Recommendation Report for Planning Permission for Works or Extension to a Dwelling

REF NO: EP/48/21/HH

LOCATION: 2 Bay Tree Garden
East Preston
BN16 1JG

PROPOSAL: Erection of single storey rear extension and rear dormer following the demolition of existing garage and workshop.

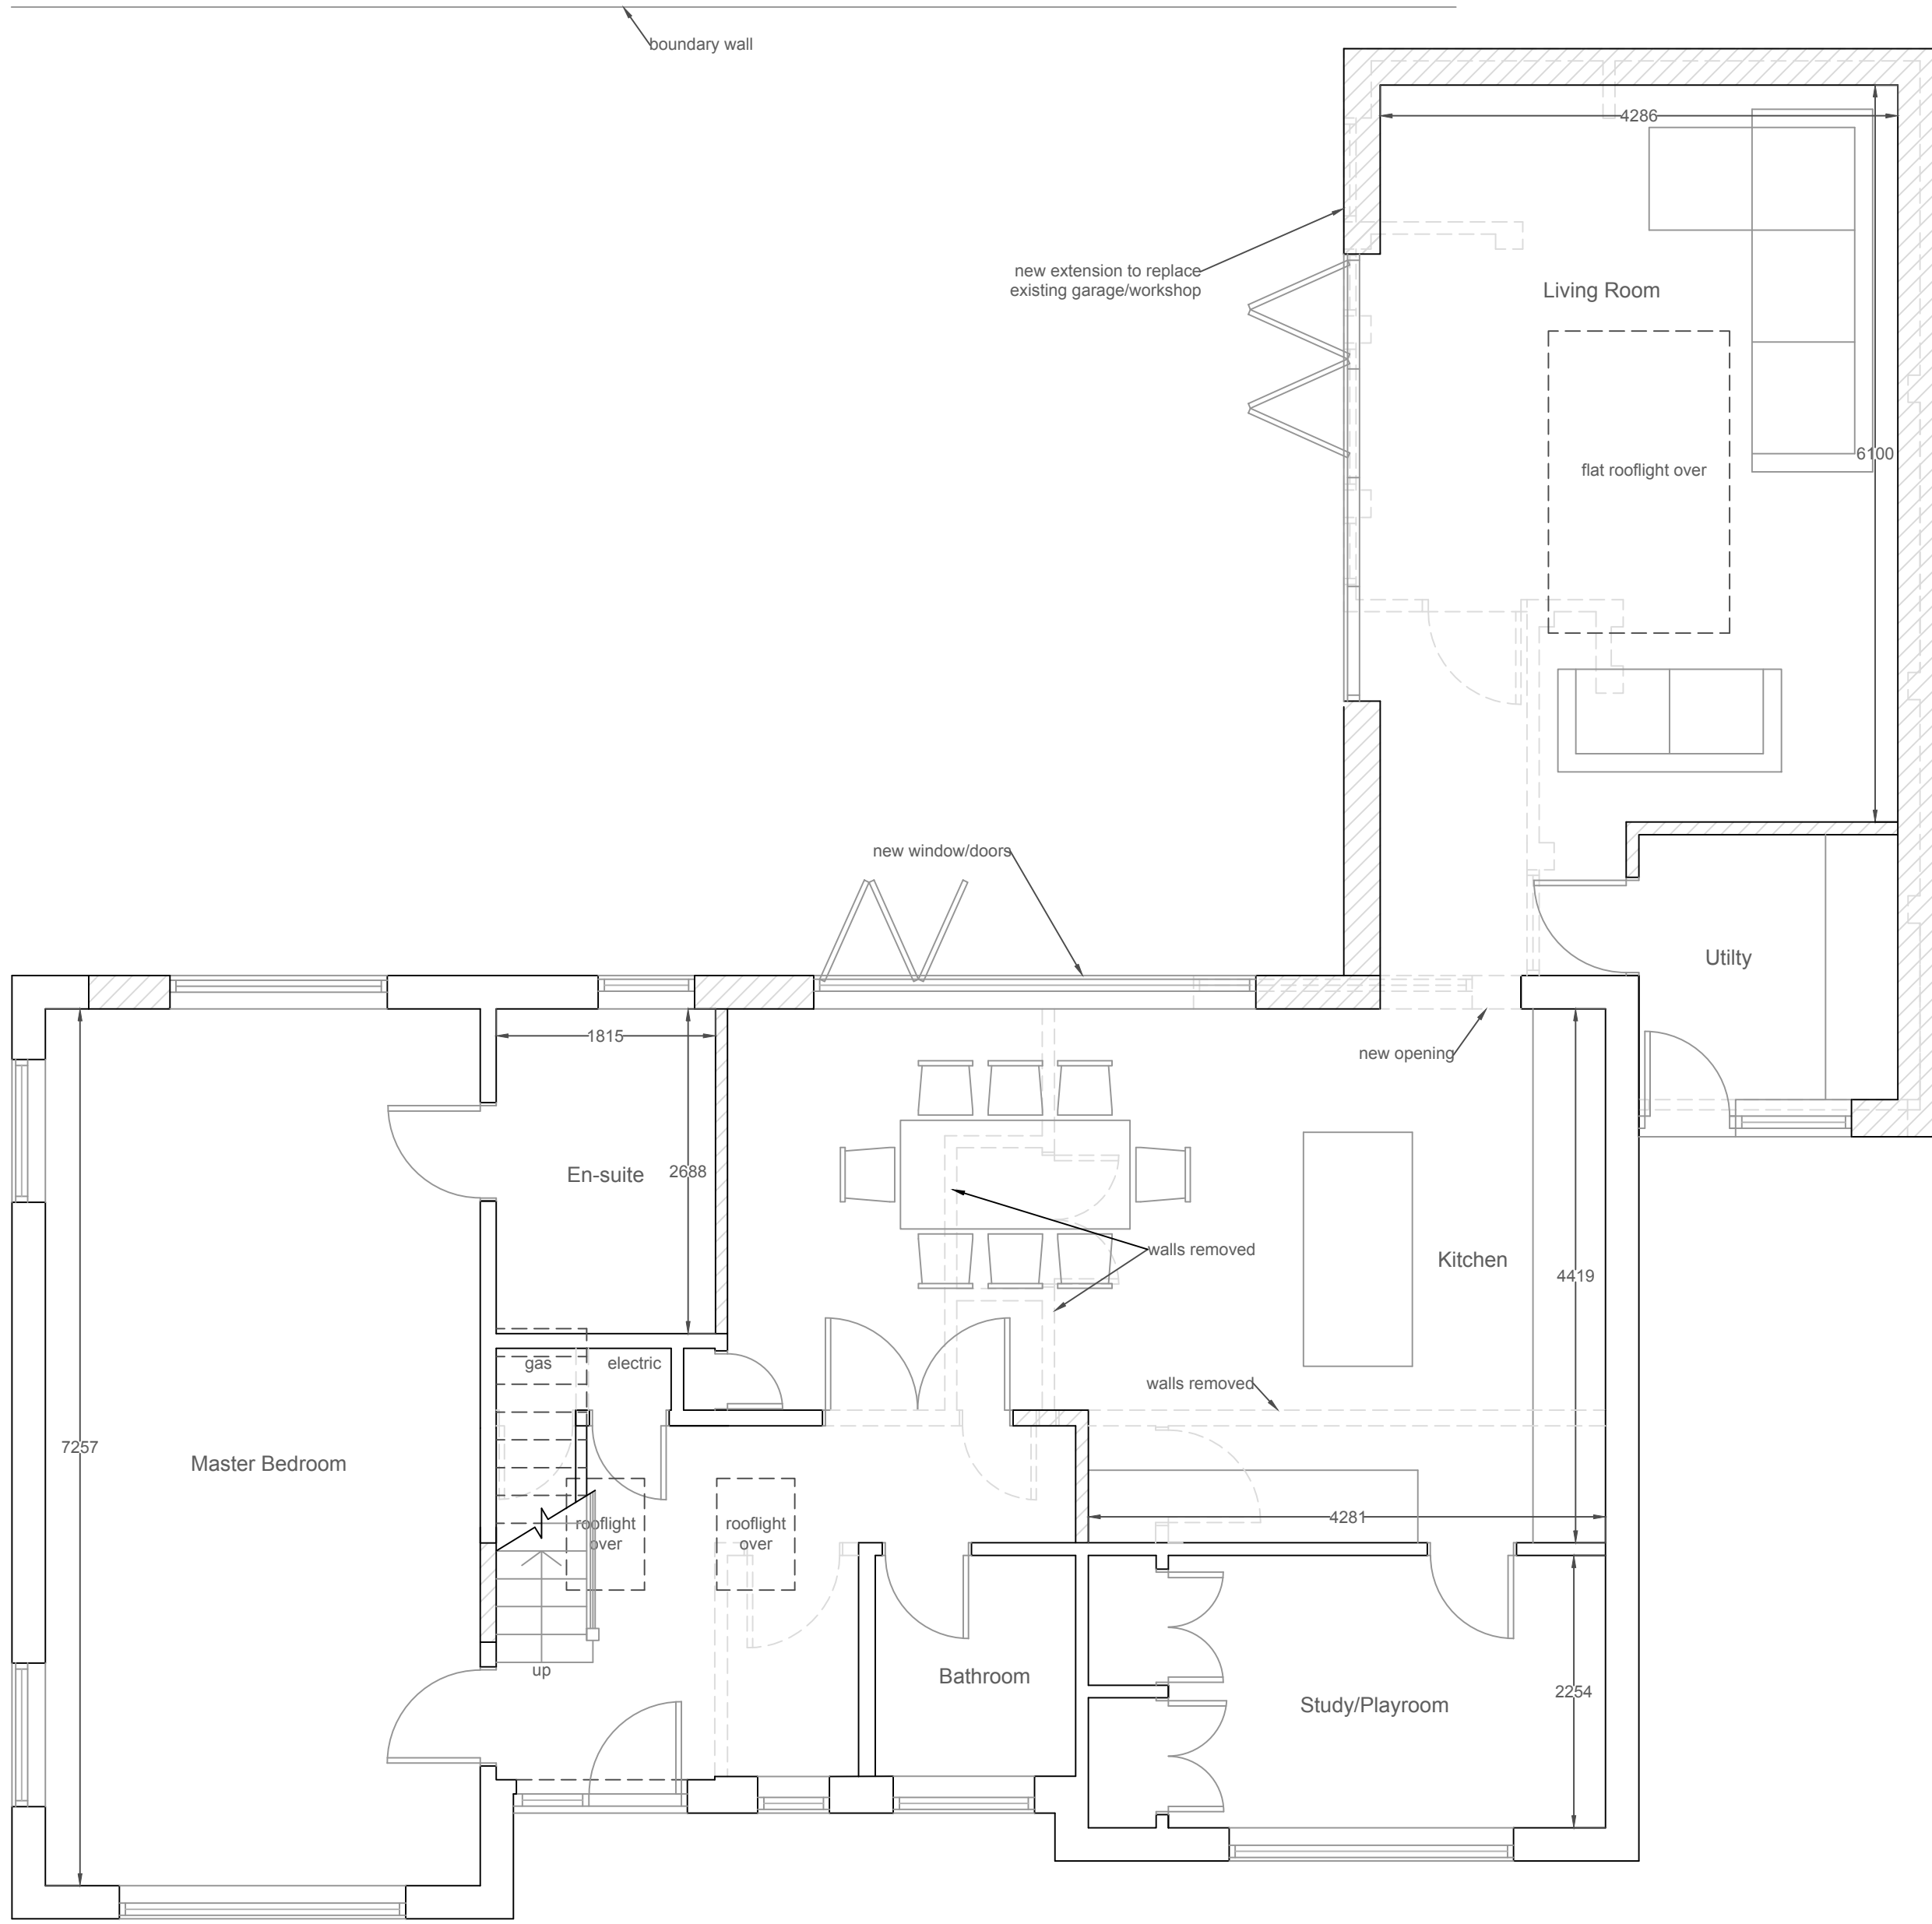
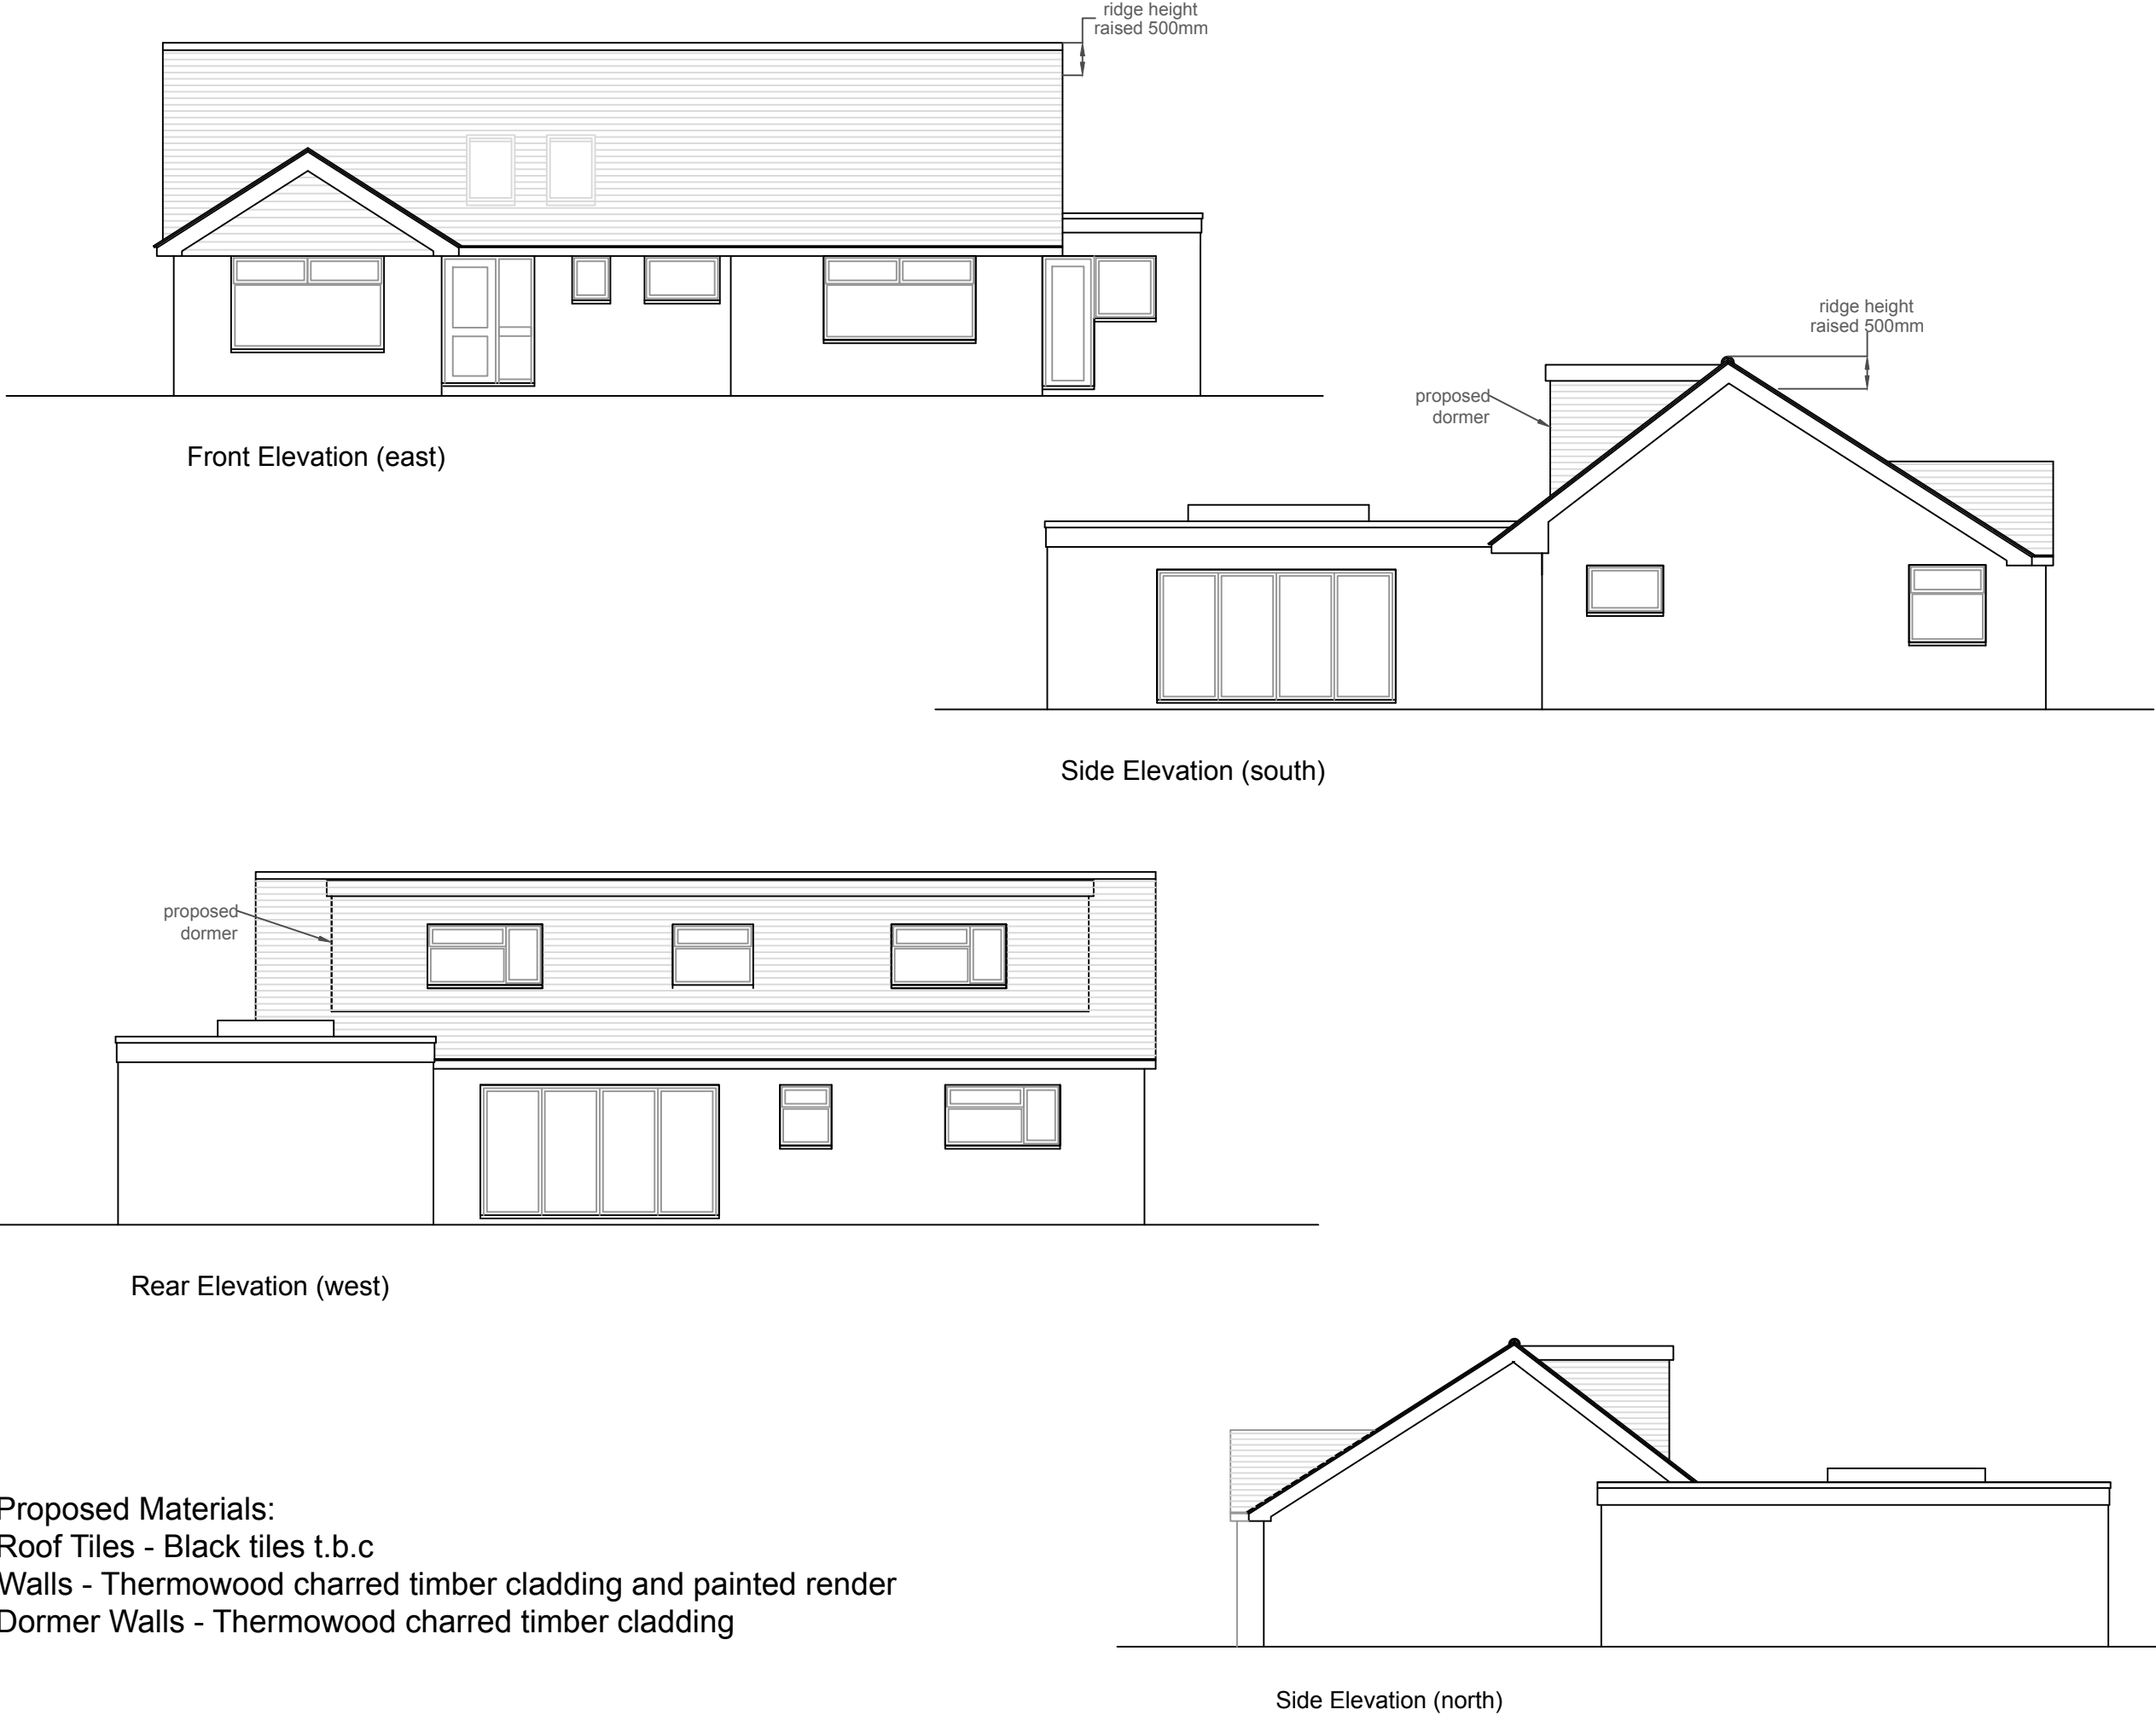
The rear dormers could be built under the provisions of permitted development. The two rooflights in the front elevation are set within the roof profile. The dormer extension in terms of design and size conflicts with Arun's Design guide part M which favours small scale roof extensions. The total allowance on the roof extension with hip to gable extension is 50 cubic metres under PD regulations. However in this case applicant has not chosen to alter the roof from hip to gable and instead increasing ridge height marginally to add rear dormers.

The single storey extension would be sited adjacent to the boundary with the adjoining property. The

layout of the extension contradicts Part M of the Arun Design Guide in terms of size, scale and position. The proposed extension is only being permitted based on the existing outbuildings which is in situ adjacent to the boundary and next to the host dwelling. The footprint of the extension would match the existing outbuilding; however the height on the northern boundary appears to be slightly higher than the outbuilding. The height is not significantly higher to warrant refusal. It is noted that adjoining property also contain extension within the residential curtilage. Therefore, no significant harm to residential amenity would be caused in terms of loss of light, loss of outlook, loss of privacy or any overbearing impact.

The application site does not benefit from the lengthy garden and it is approximately 7.8m in depth. There are residential properties sited at the rear of the application site and due to the orientation of these dwelling, the dormer windows would not afford direct views in the private habitable areas. The total height of the dwelling is approximately 5.5m high and the dormer window are set below the roof profile; therefore it is considered that the proposal would not cause significant overlooking which would be detrimental to living conditions of the nearby occupiers. The roof extension would encompass two rooflights in the front elevation, there would access to natural light to the bedrooms; therefore planning condition would be imposed for obscure glazing.

- 3 The dormer windows in the rear elevation of the dwelling for bathroom and two bedroom windows shall be glazed with obscured glass and non-opening above 1.7m.
